**KIRKLEES METROPOLITAN COUNCIL  
TOWN AND COUNTRY PLANNING ACT 1990  
HIGHWAYS DEVELOPMENT CONTROL KP20H**

**PLANNING REF** 2012/62/92106/E0/SL  
**CATEGORY** Small Major

**PROPOSAL** ERECTION OF SUB-TERRANEAN  
DWELLING AND ASSOCIATED WORKS

**LOCATION** DENBY LANE  
UPPER DENBY  
HUDDERSFIELD  
HD8 8XZ

Plans, Elevations & Site Plan
As Proposed

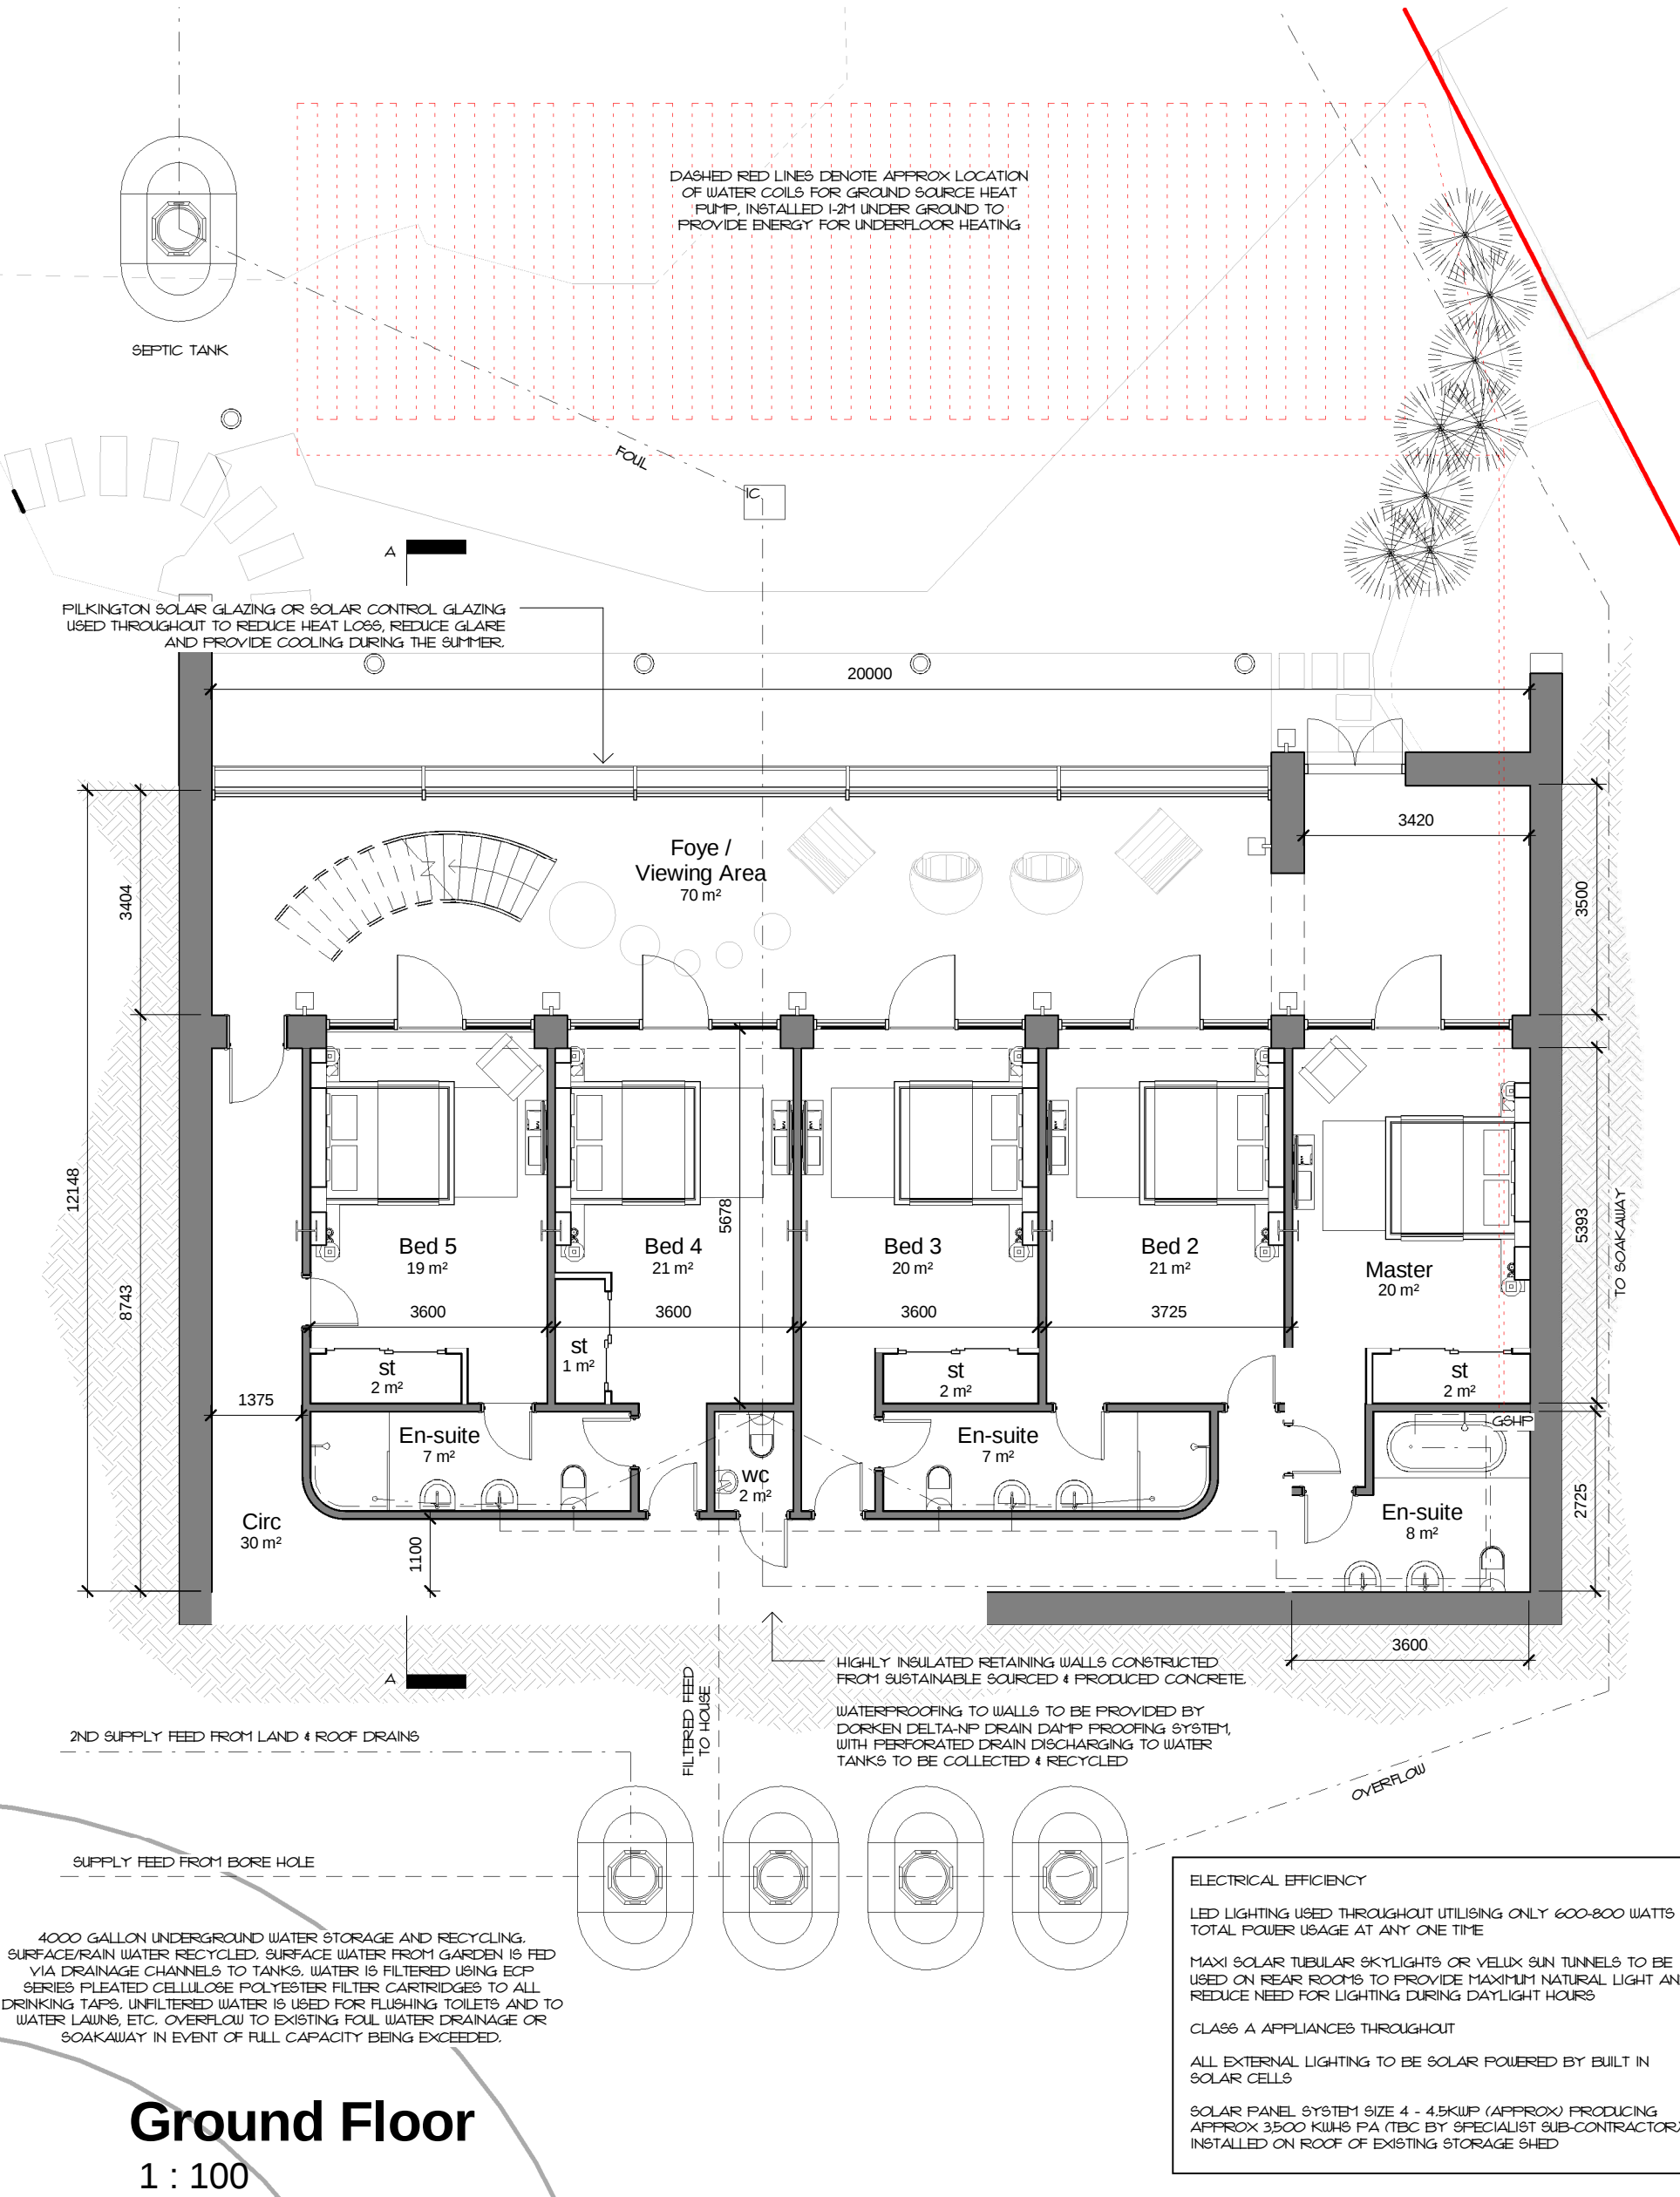
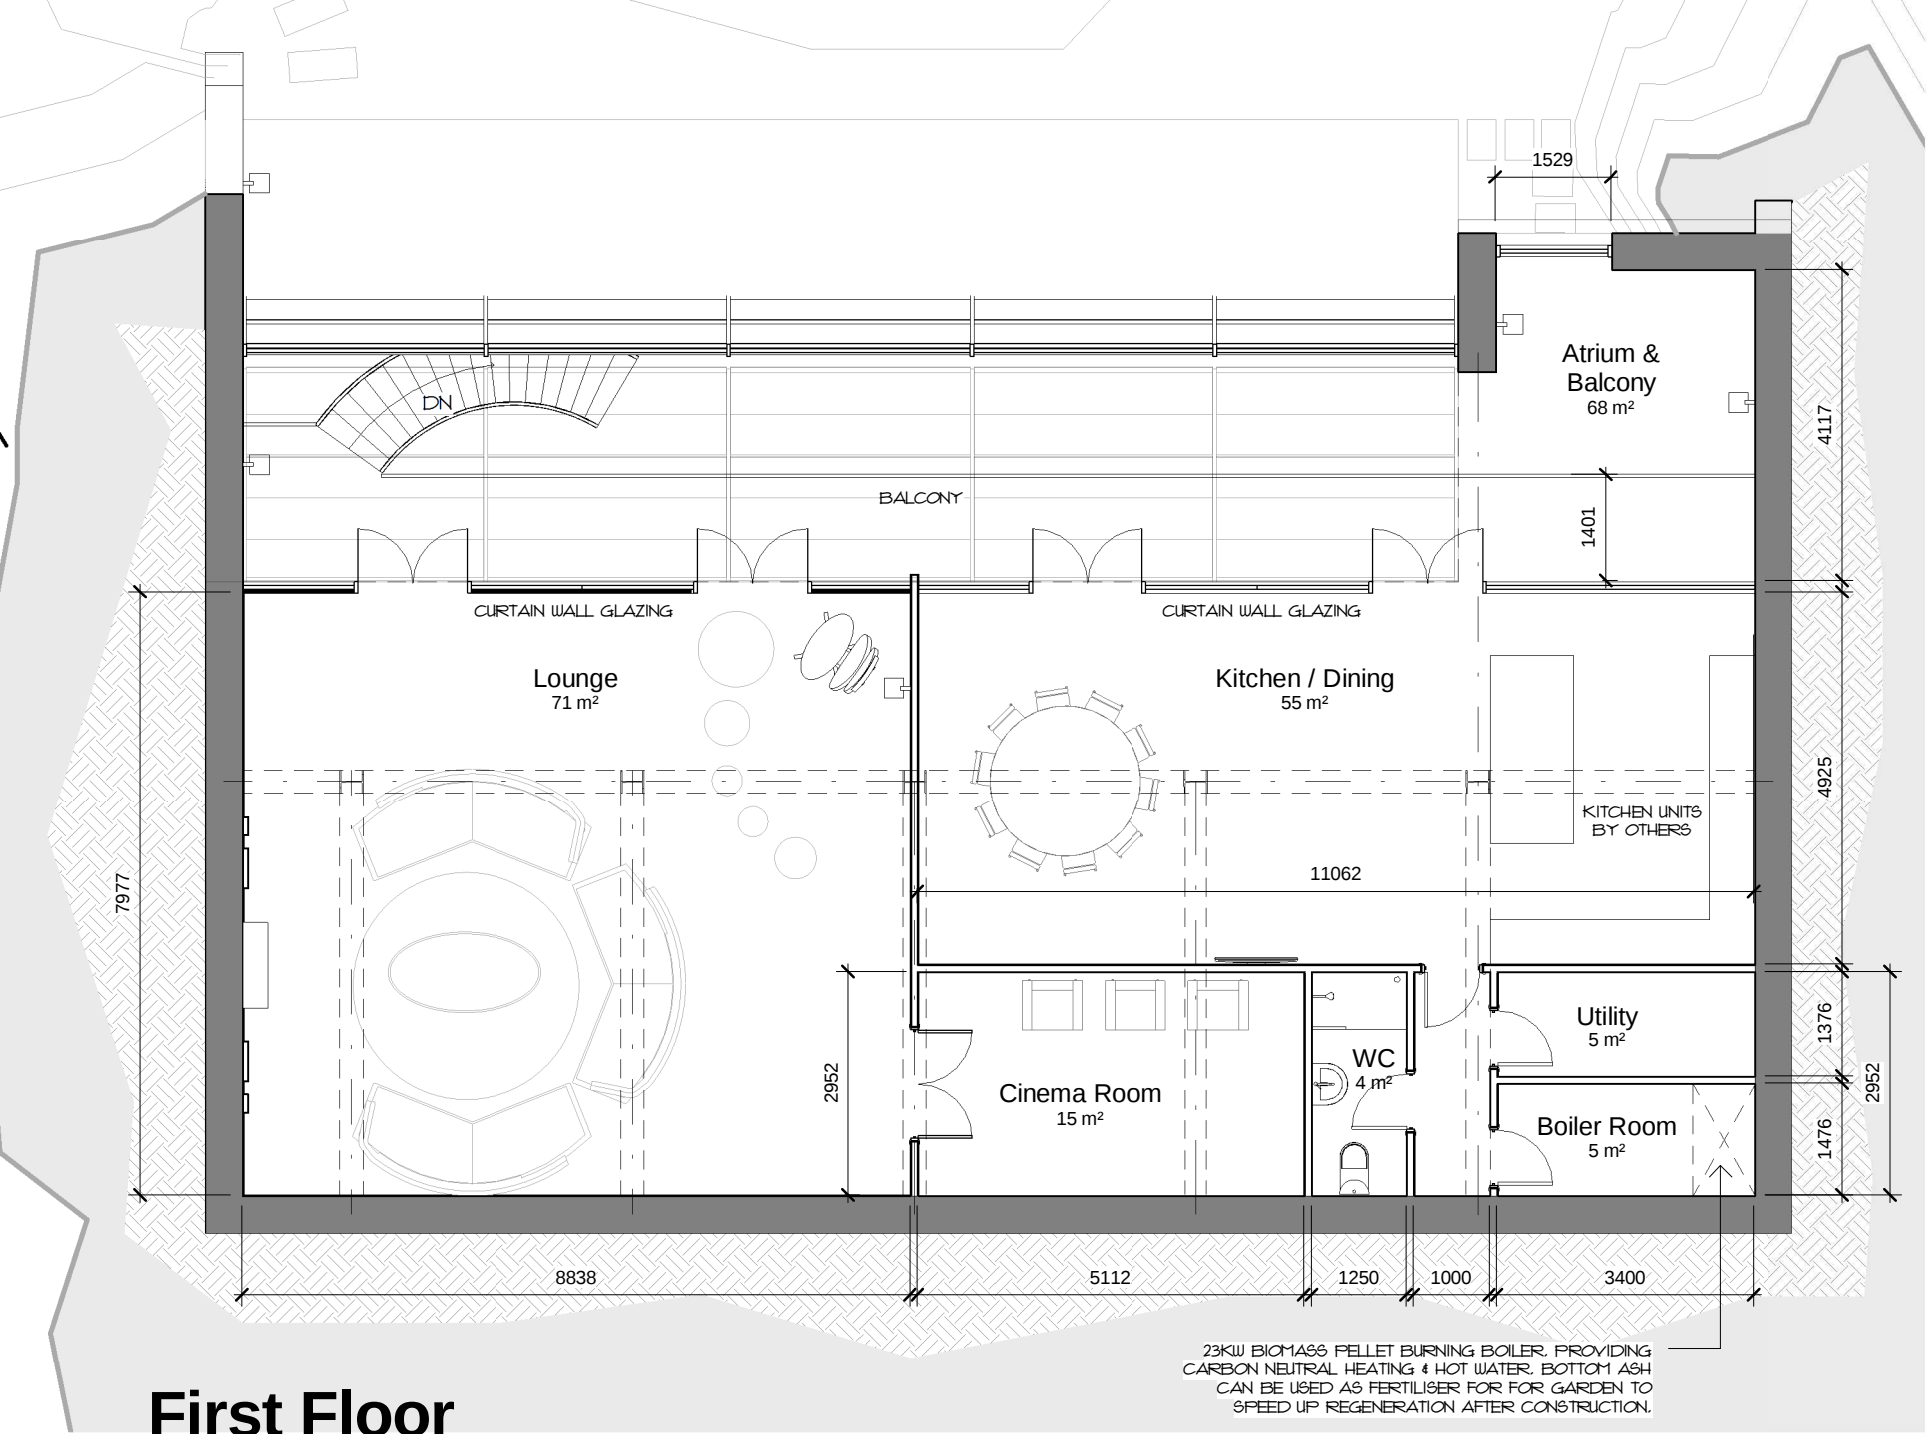
Whilst there is adequate space within the site to accommodate parking and servicing given that the site is in green belt the application needs to identify parking and servicing arrangements together with the curtilage of the dwelling.
